DEVELOPMENT REVIEW BOARD
TRANSPORTATION DEVELOPMENT

DRB Project Number: 2021-001579
Winrock Park

SUBJECT: Plat, Site Plan

ENGINEERING COMMENTS:

DATE: 9/29/2021	sheet: SP-1A
SCALE: RE: SCALE	of.

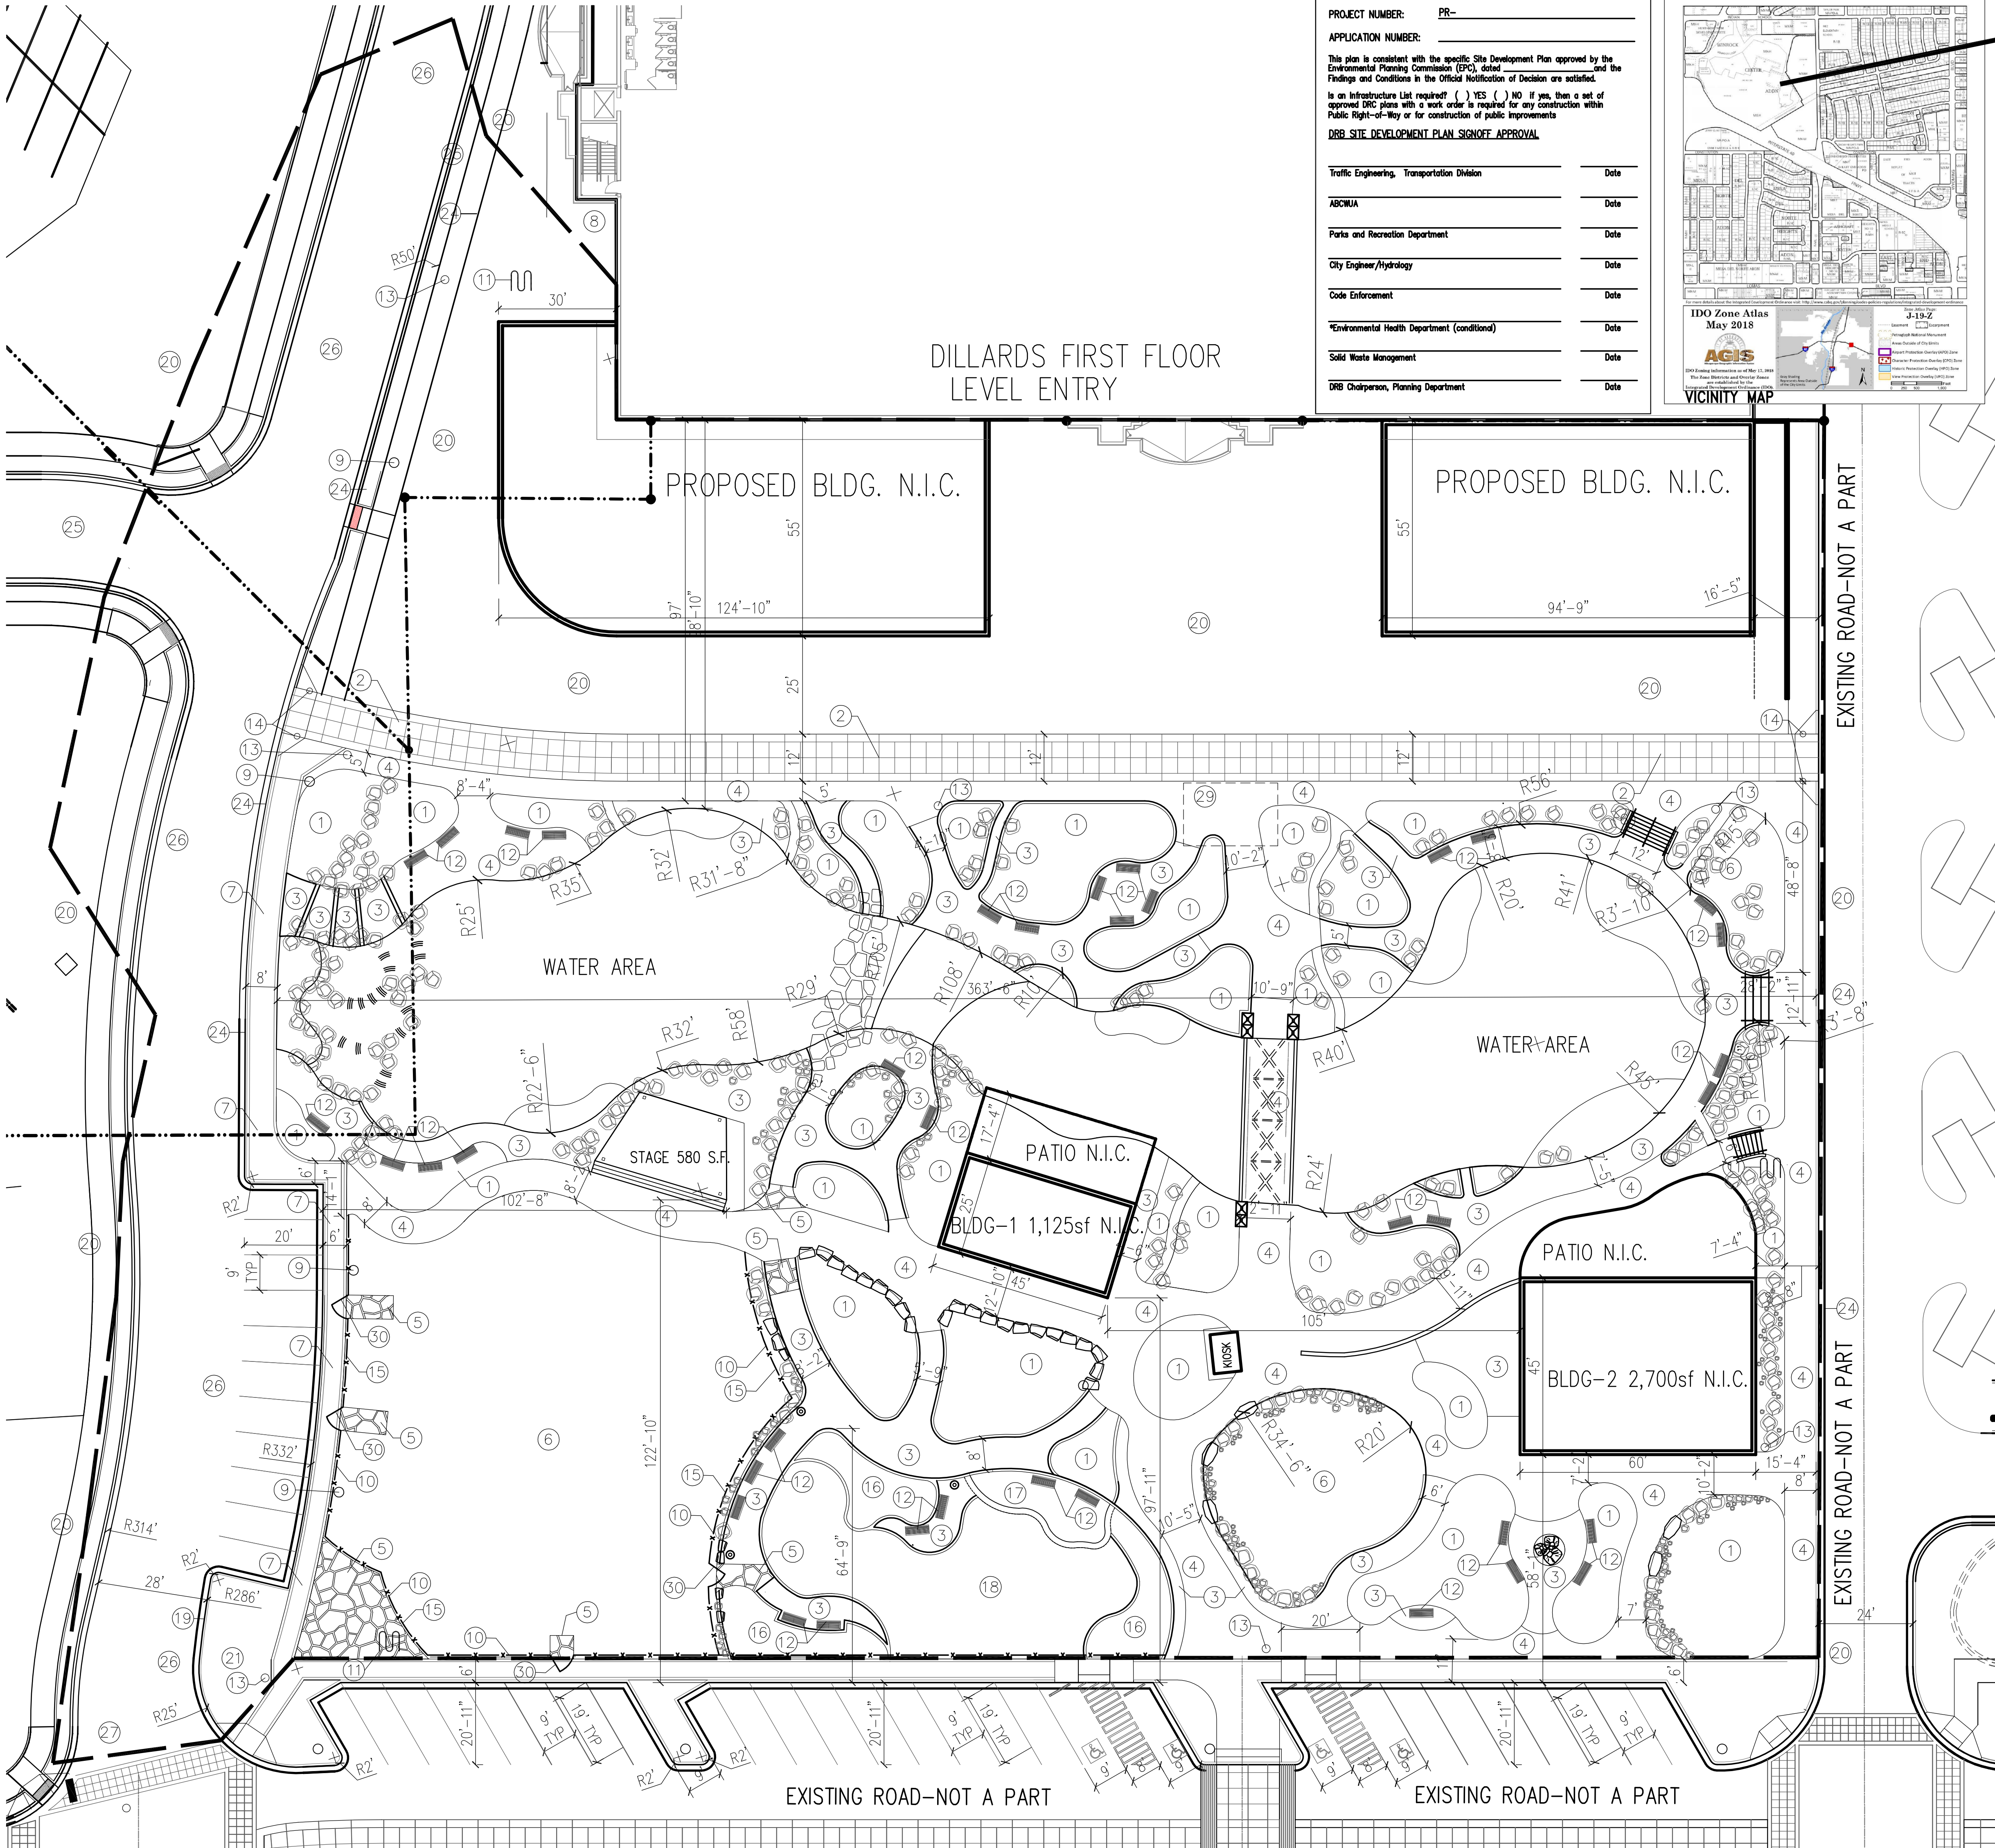
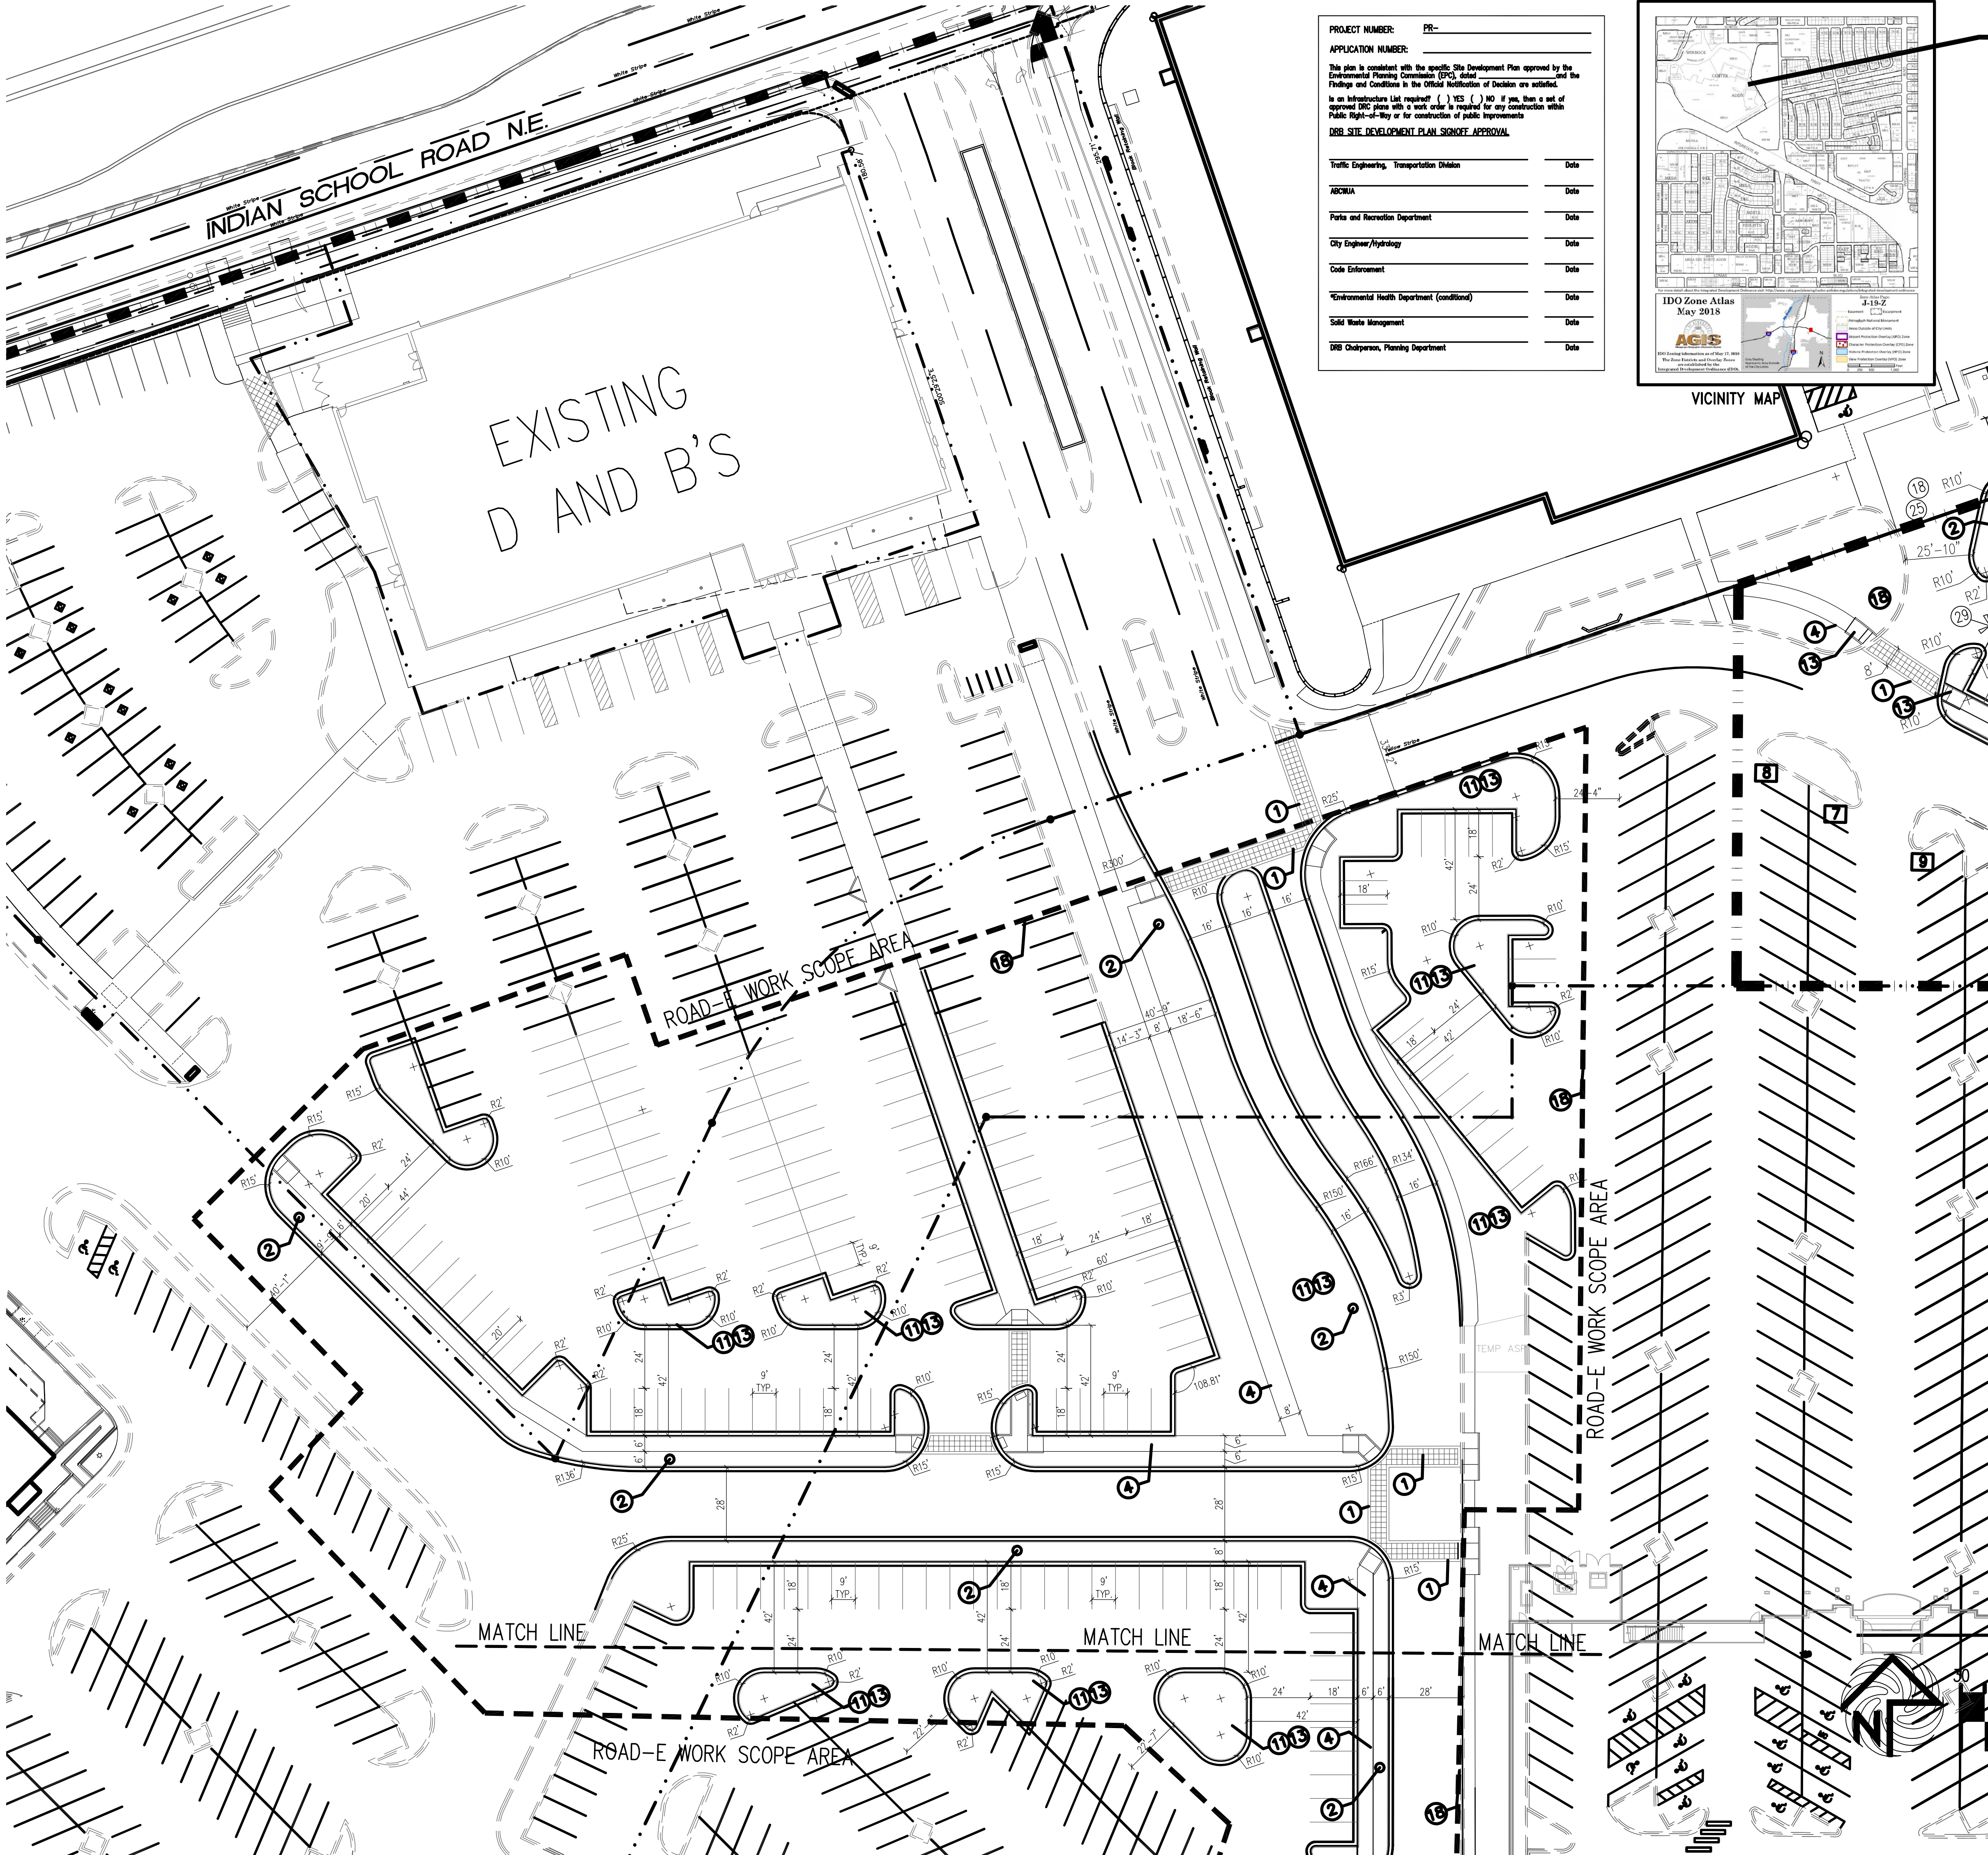
1. Stamp and sign drawings.
2. Show cross-sections of Roadway E with cross-slopes, lane widths and sidewalks. Call out details for curb.
3. Label all handicapped signage and motorcycle parking signage on the plan.
4. Provide proposed traffic control at each of the new intersections. Add “Yield to Pedestrians” signage for the new crosswalks that are mid-block.
5. Include civil details with all signage, curb, ramps, and sidewalk, and crosswalk details. For the curb ramp and sidewalk details, indicate a 2% maximum slope for the sidewalk.
6. Label all new curb ramps on the site plan and reference curb ramp details. (It appears that in some cases, the wrong keyed notes were used for the curb ramps.)
7. “No Parking” shall be called out on all new van accessible aisles. However, this can be handled under the details.
